**In reply please quote:** 19/29449  
**Your reference:** SS1 9364

20 November 2019

**M12 MOTORWAY (SSI-9364) – ENVIRONMENTAL IMPACT STATEMENT (EIS)**

Figure 7-111 Receivers identified as eligible for consideration of additional mitigation

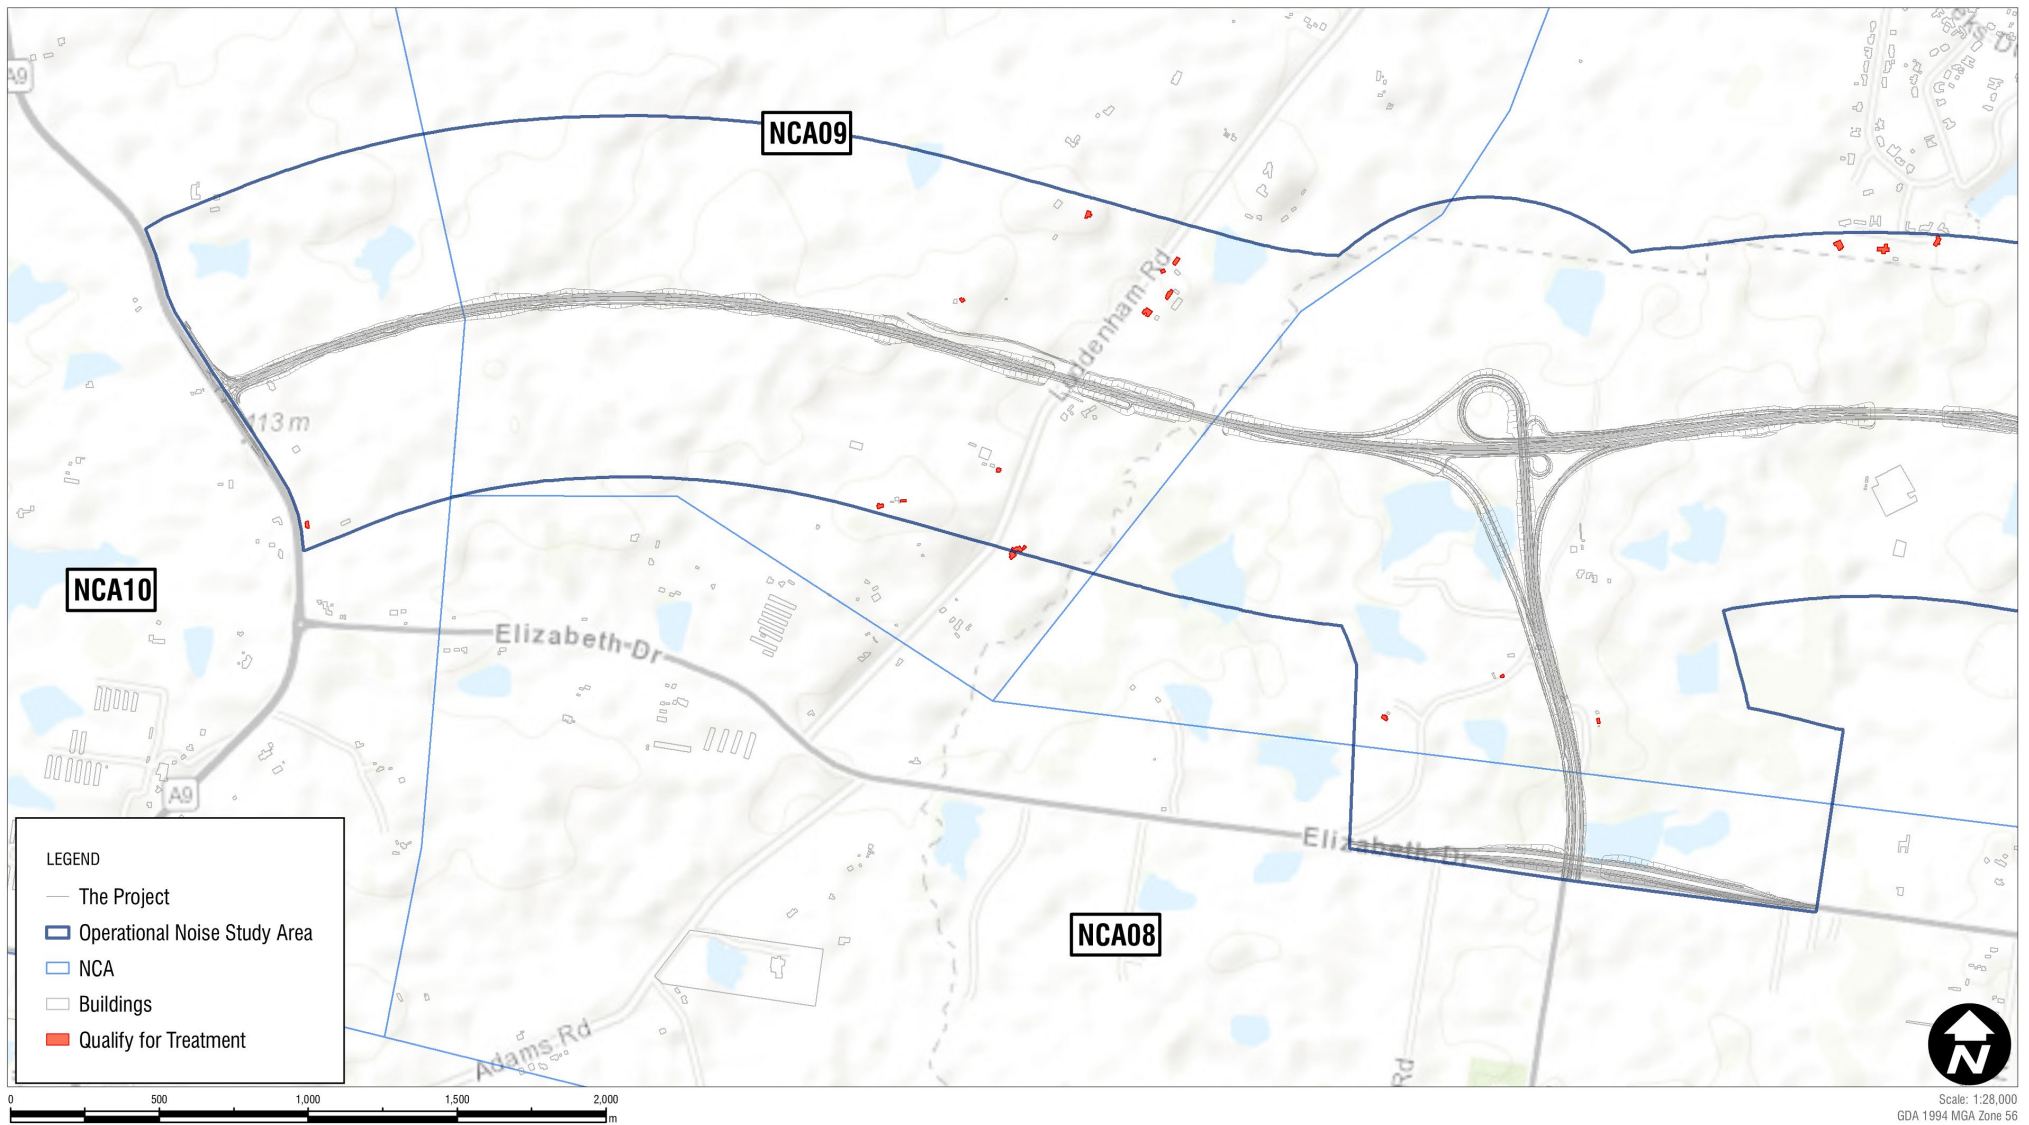
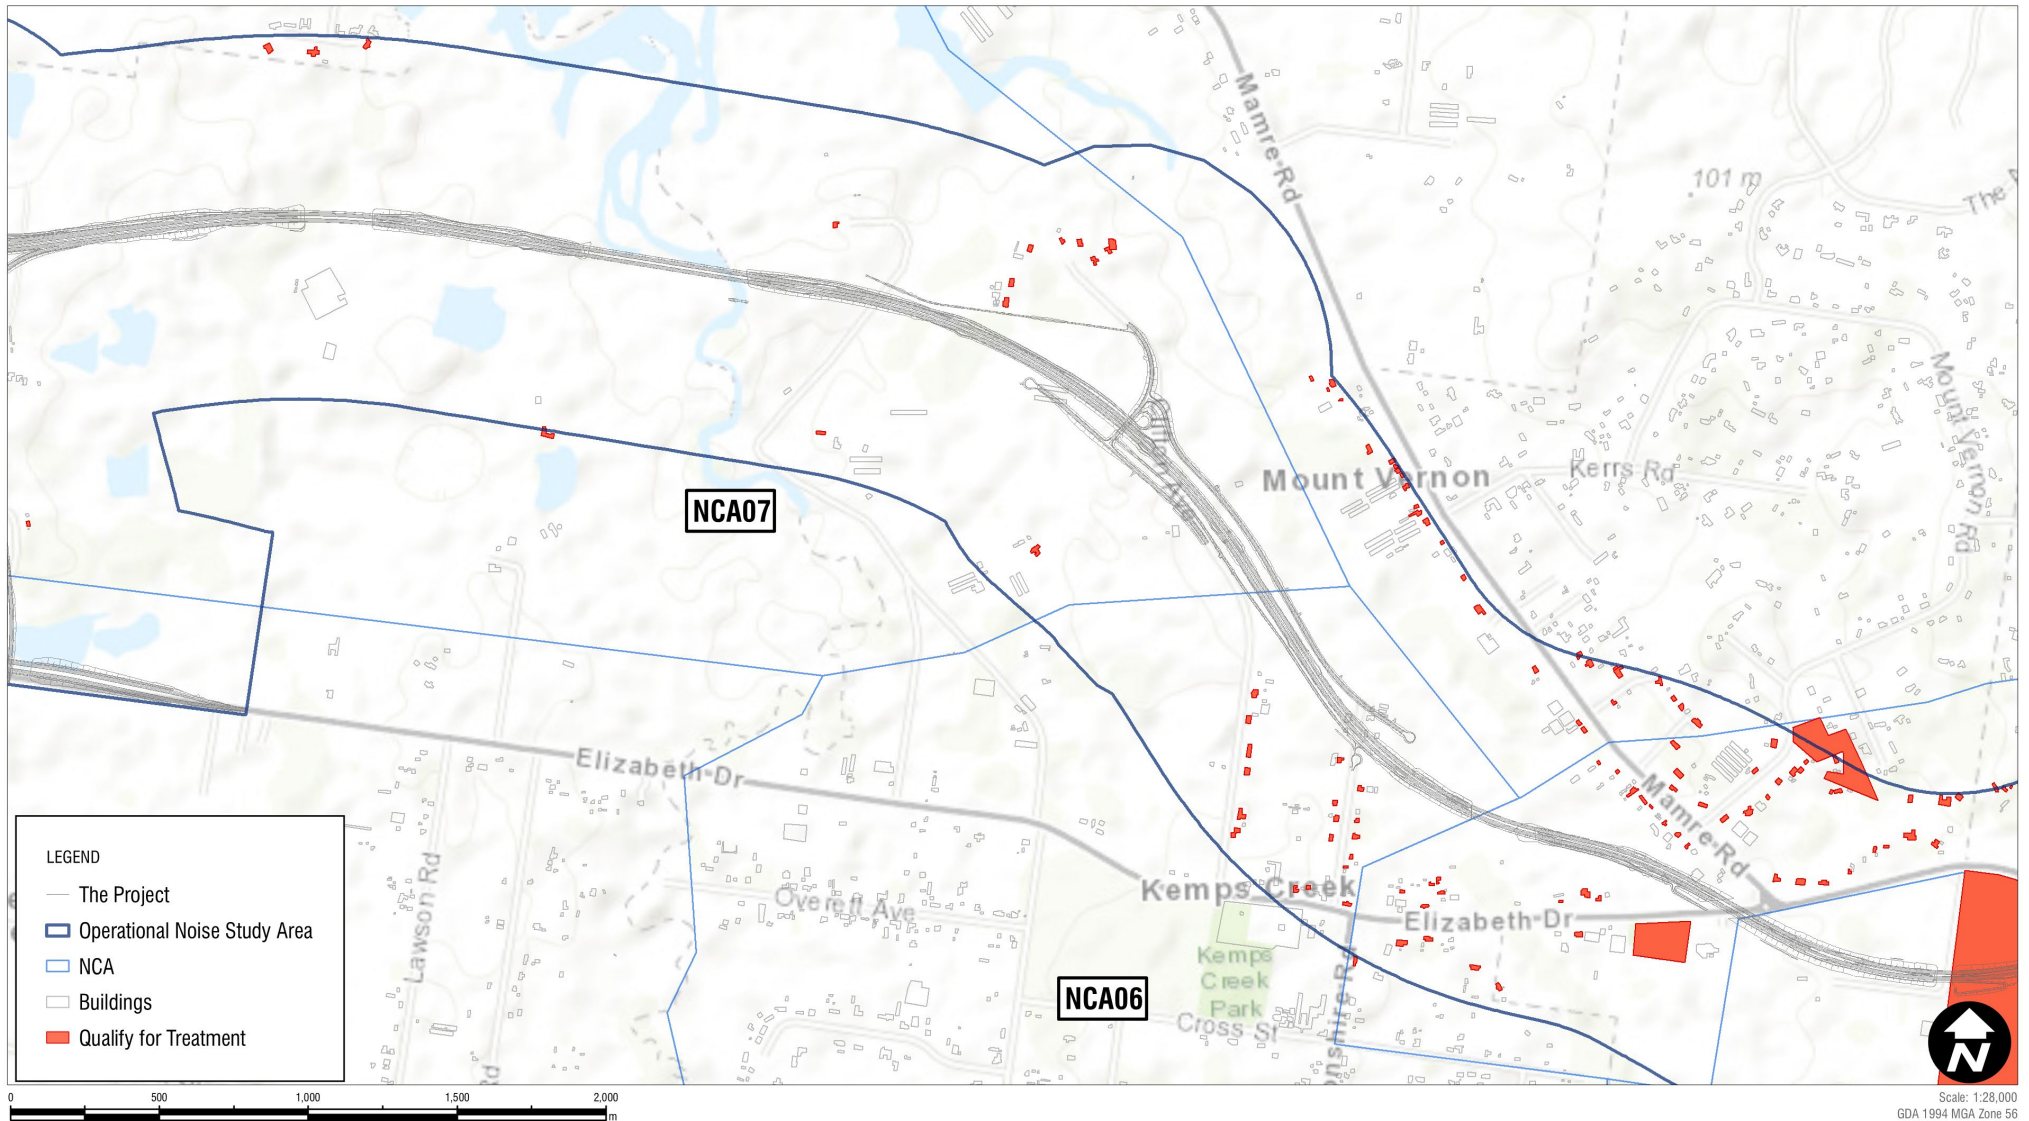
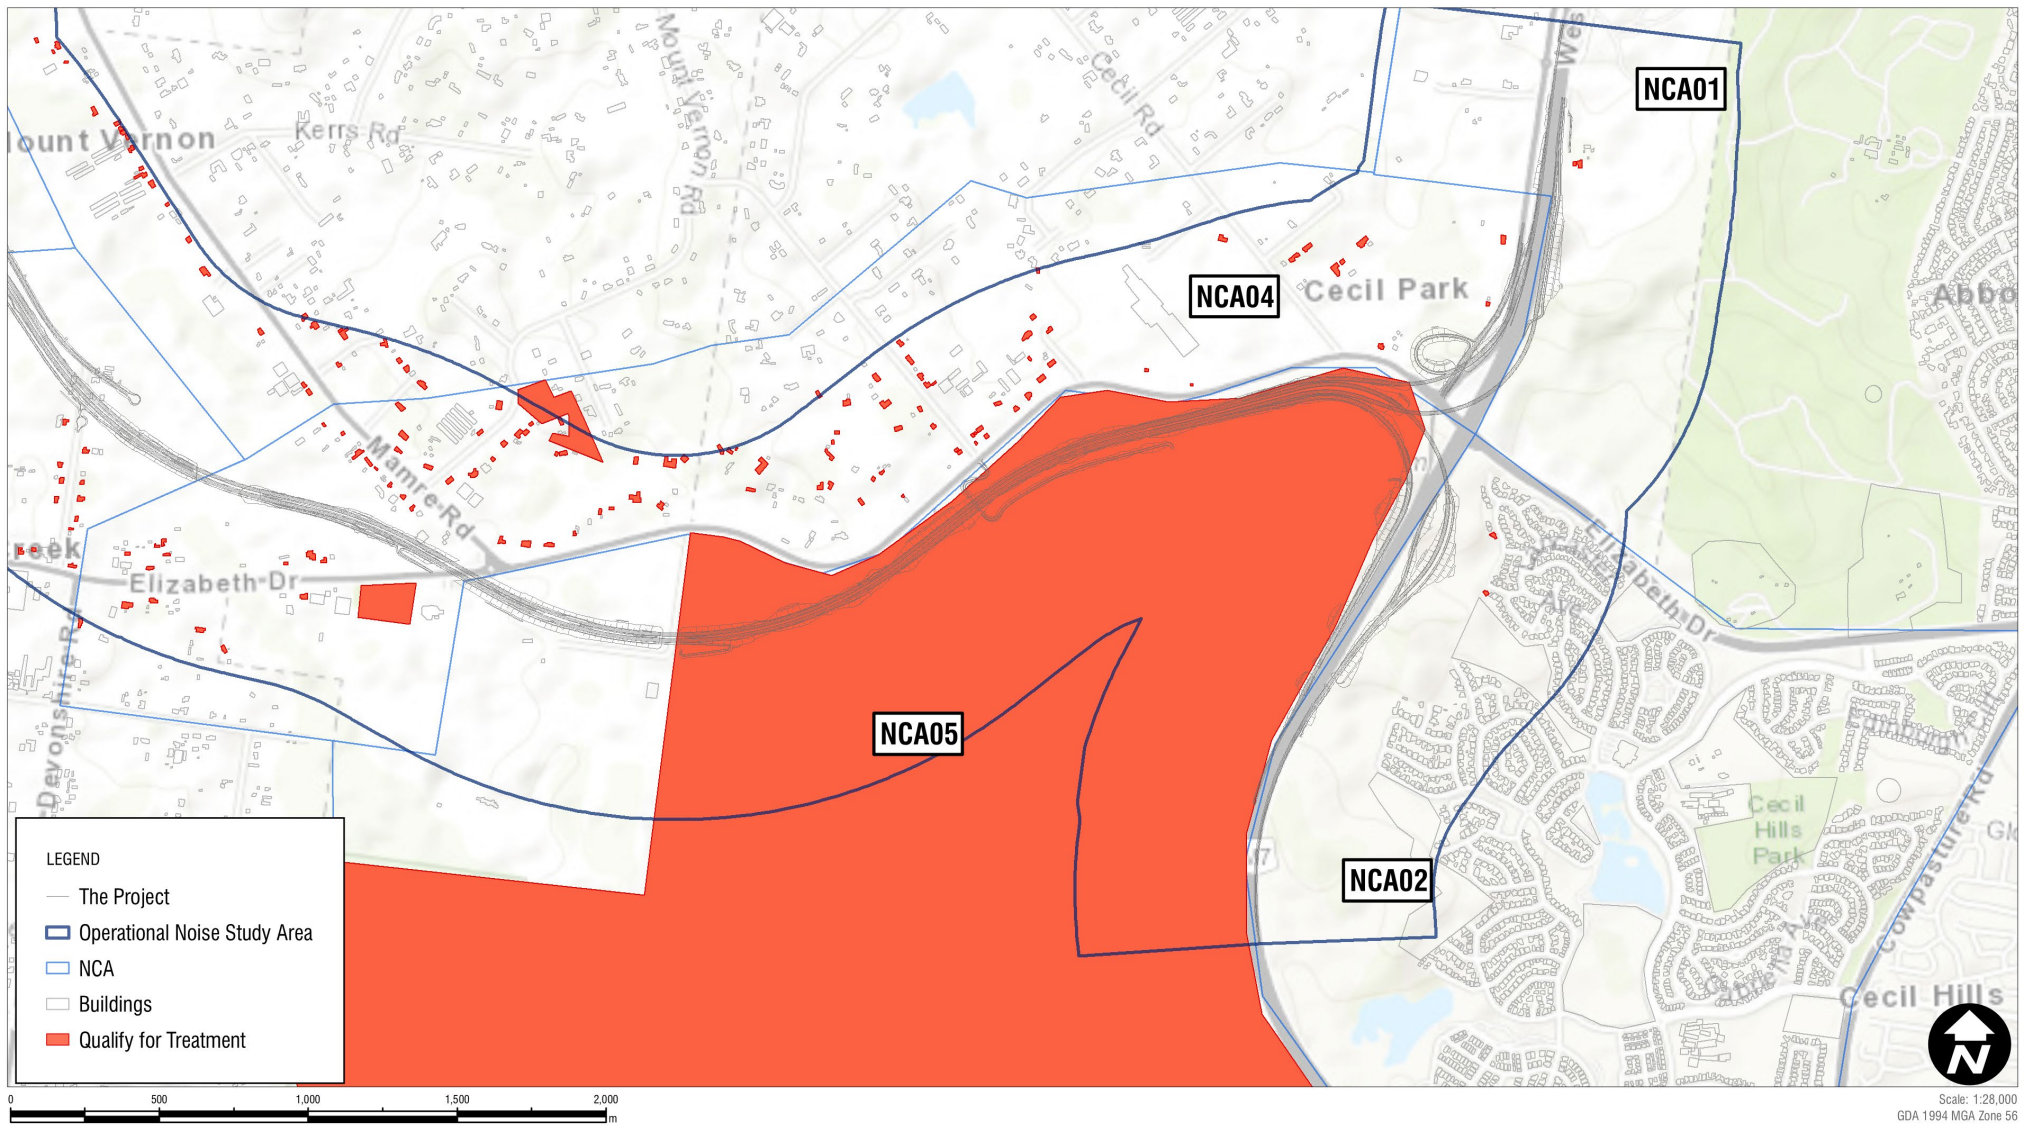
Information included in the EIS (image below) indicates the location of the proposed town centre in Cecil Park would be highly impacted by traffic noise associated with operation of the M12 corridor that would reach levels of between 40-60dba at night-time by 2036.

This fact is not acknowledged in the EIS that treats the locality as rural lands and does not consider the constraints created for potential future high density residential development in the area. This includes the need for mitigation measures both in design of the M12 (including noise attenuation measures) and implications for the design and layout of the potential Cecil Park Town Centre.

In addition to the above, the noise impact assessment undertaken for the M12 corridor focuses on a relatively narrow study area running along the length of the proposed motorway corridor. Information about the extent of noise impacts on the remainder of the UIA in Cecil Park has not been included in the EIS. Again, this is a major shortcoming of the EIS. Further information in regard to noise impacts is detailed further in this submission.

The operational noise assessment compares road traffic noise levels predicted due to the project in 2026 (modelled as the year 'at opening') and 2036 (modelled as 10 years after opening) with those predicted without the project. The noise assessment has a fatal deficiency in that it does not account for the Fairfield Rural Lands UIA.

The UIA has progressed to the point that rural areas directly impacted by the proposed M12 are identified for potential residential, commercial and industrial zones following the opening of the M12. This scenario has not been accounted for in the noise operational assessment.

The addition of the UIA scenario would affect recommendations for type and amount of noise mitigation for the operational phase of the M12.
